## Rezoning Petition Review

**Date of Review:** February 24, 2020 (**Revised March 23, 2020**)

**Rezoning Petition #:** 20-02

**Location of Property:** Approximately 0.55 acres located on the northeastern side of Vail Ave, south of Deacon Ave and southeast of Dotger Ave.

SCHEMATIC SITE PLAN

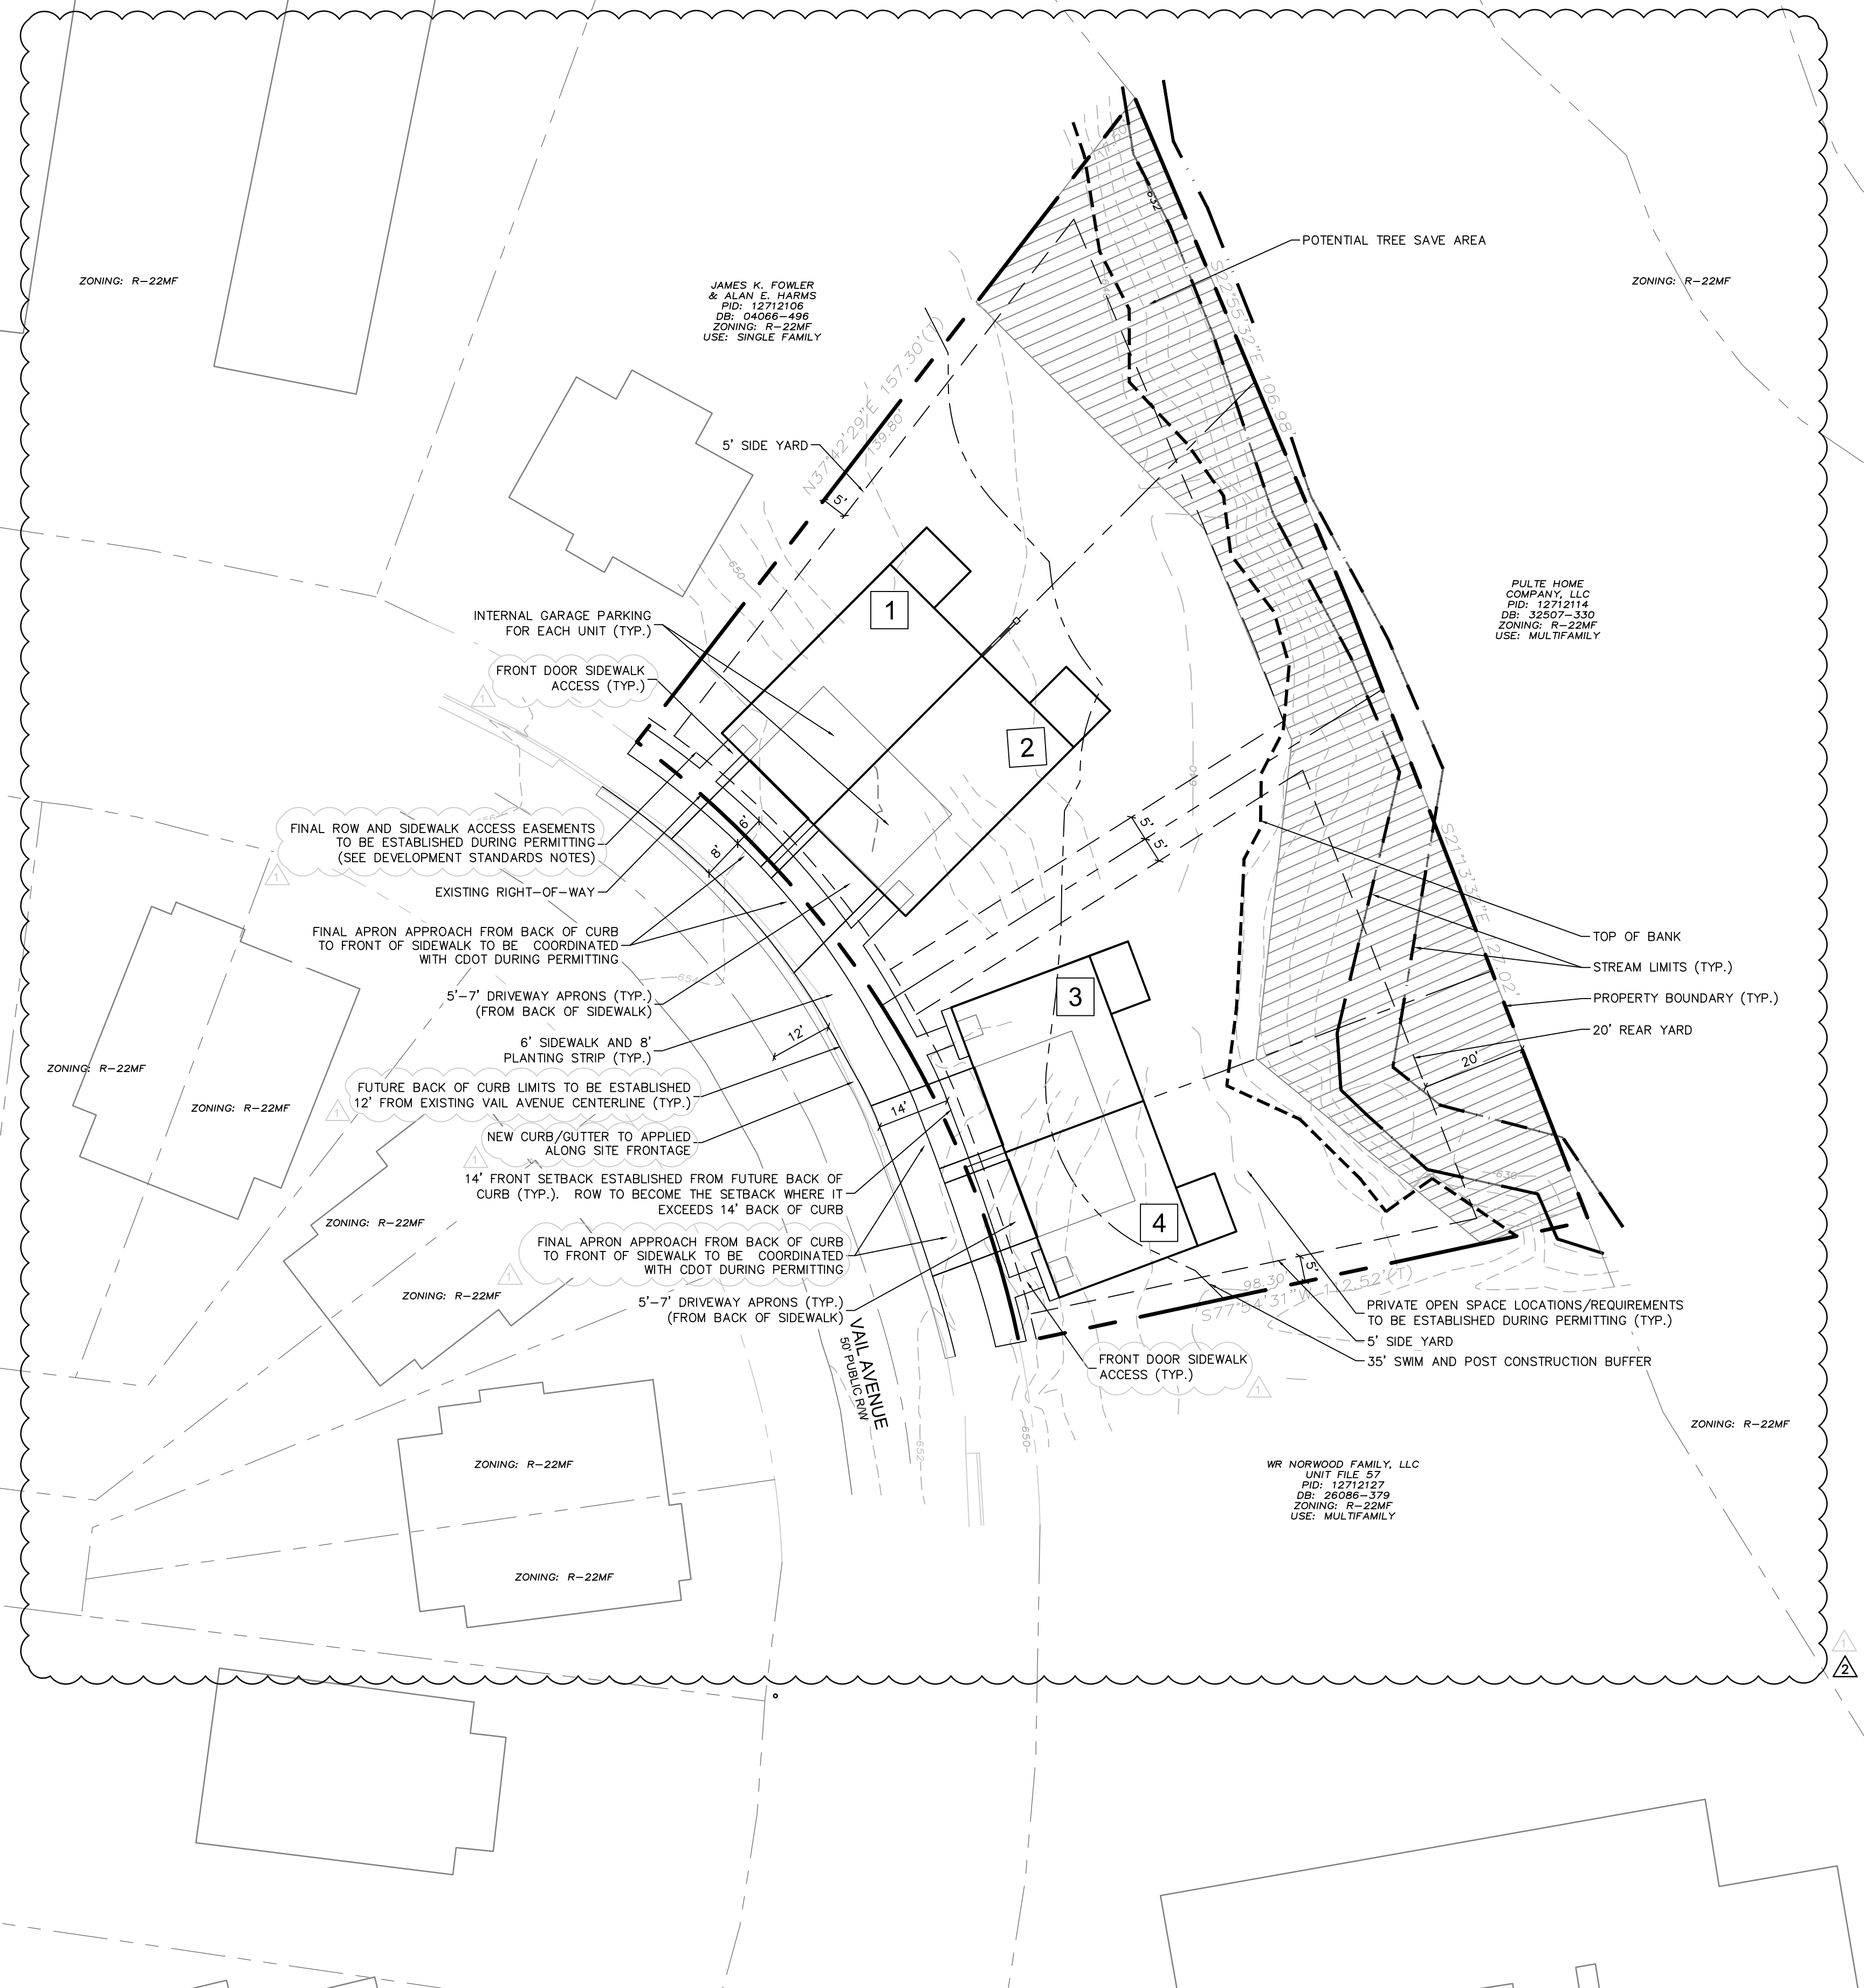
Please replace the second sentence under note #1 of "Environmental Features" with the following: *"Development within the SWIM/PCSO Buffer shall be coordinated with and subject to approval by Charlotte-Mecklenburg Storm Water Services and mitigated if required by City ordinance."* Please note Stream Delineation Reports are subject to review and approval by Charlotte Storm Water Services.

**This property drains to Briar Creek, which is an impaired/degraded stream, and may contribute to downstream flooding. This project has the opportunity to mitigate future impacts to this stream, therefore, Storm Water recommends placing the following notes on the plan:**
